CASE OFFICER DELEGATED REPORT: HOUSEHOLDER

APPLICATION NUMBER: 20/01359/APP

PROPOSAL: Enlargement of approved external raised decking area, new rear patio and the insertion of a Juliet balcony in north (side) elevation.

LOCATION: 23 Hilltop Avenue Buckingham Buckinghamshire MK18 1YQ

PROPOSED NORTH (SIDE) ELEVATION

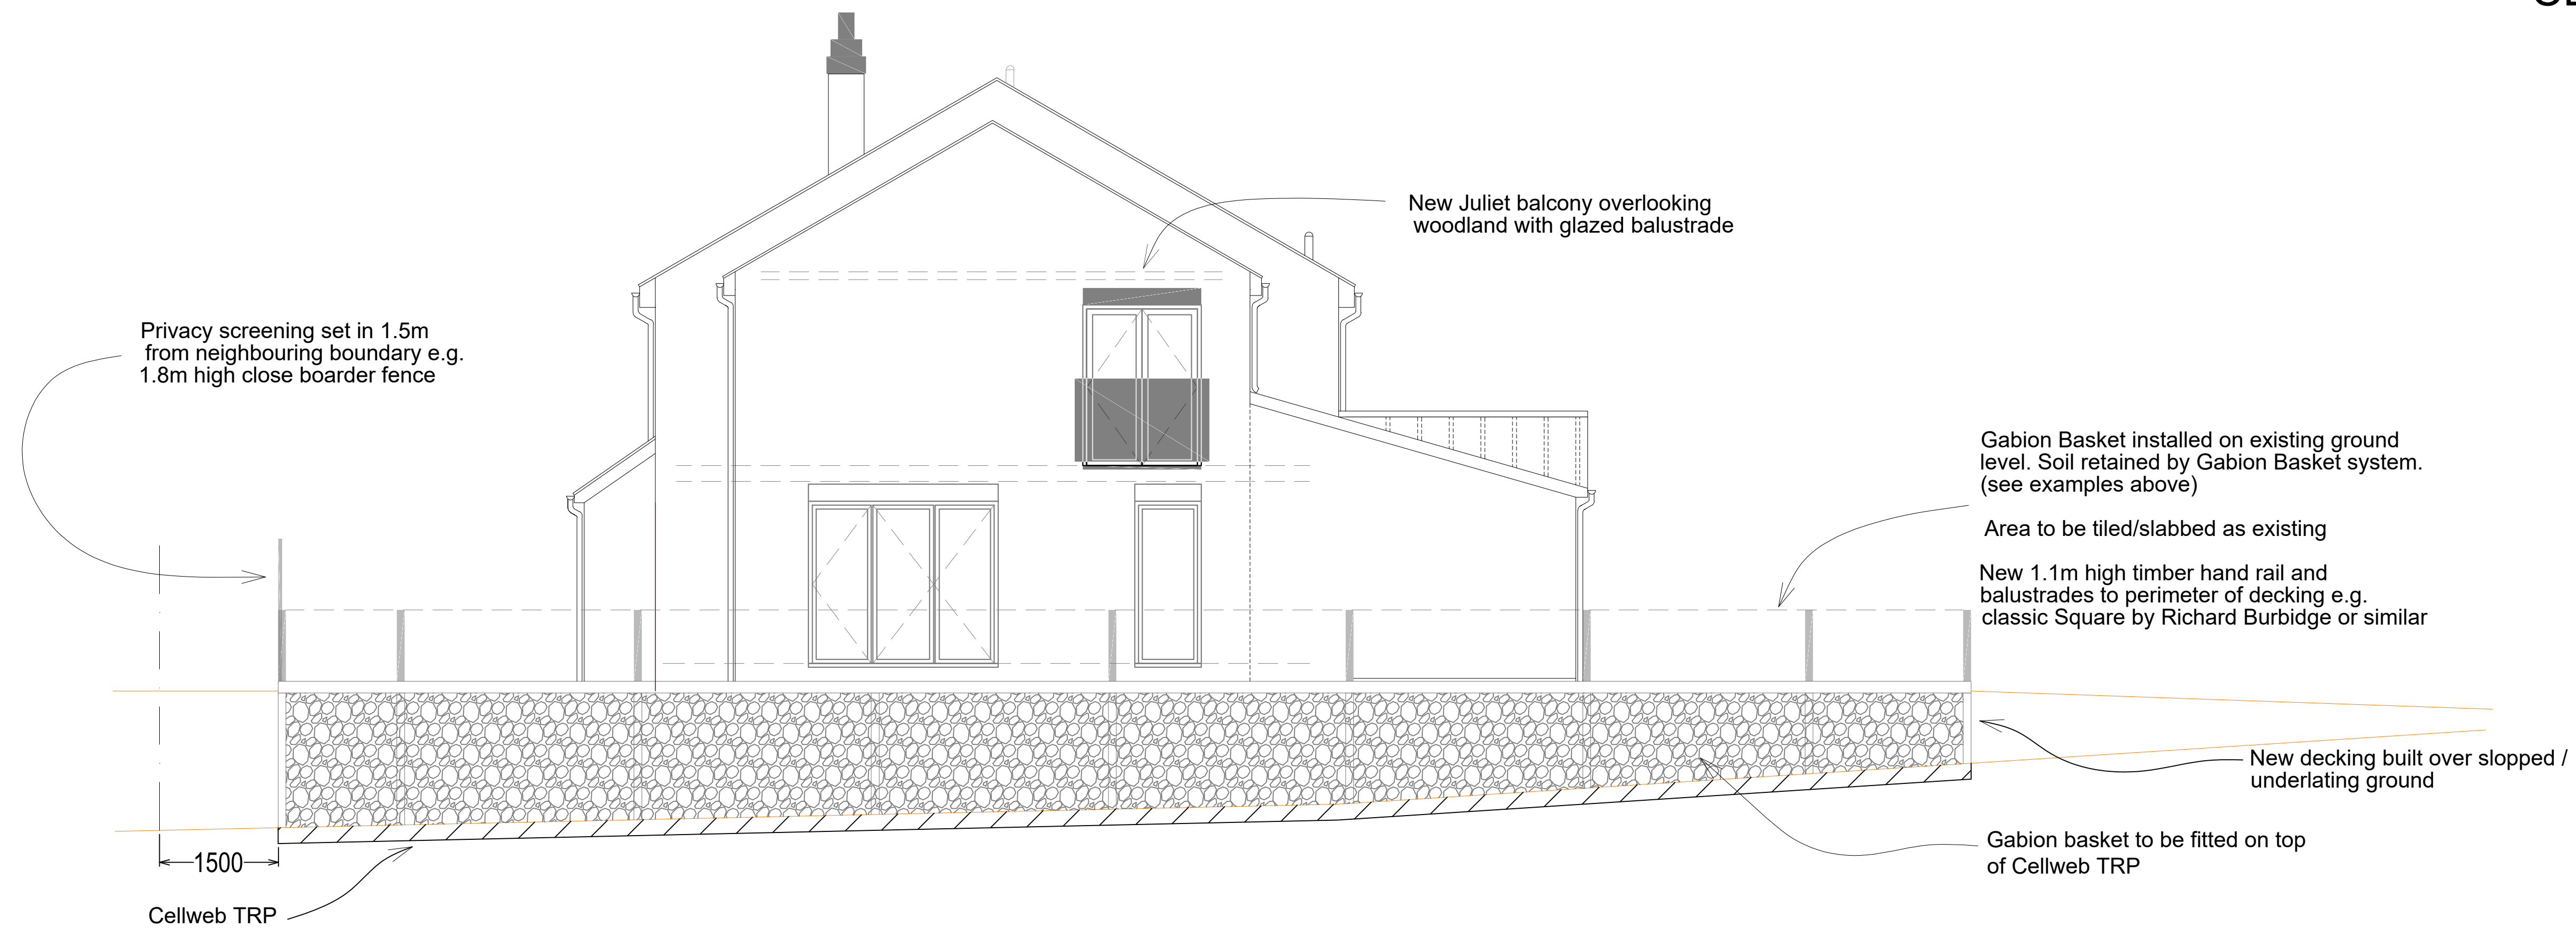
Buckingham Town Council object to the external decking as members noted that the enlarged decking area encroached into the RPA of a Protected oak tree, part of a Protected woodland, and would like a professional opinion of the likely damage to and effect on the tree and its root system with the installation of the supports, and advice on minimising this - construction methods to be conditioned.

5. Details of the proposed foundations, which will be designed to avoid negative impact upon the roots of retained trees, shall be submitted to and approved in writing by the Local Planning Authority before any development takes place. The foundations shall only be constructed in accordance with the approved details.
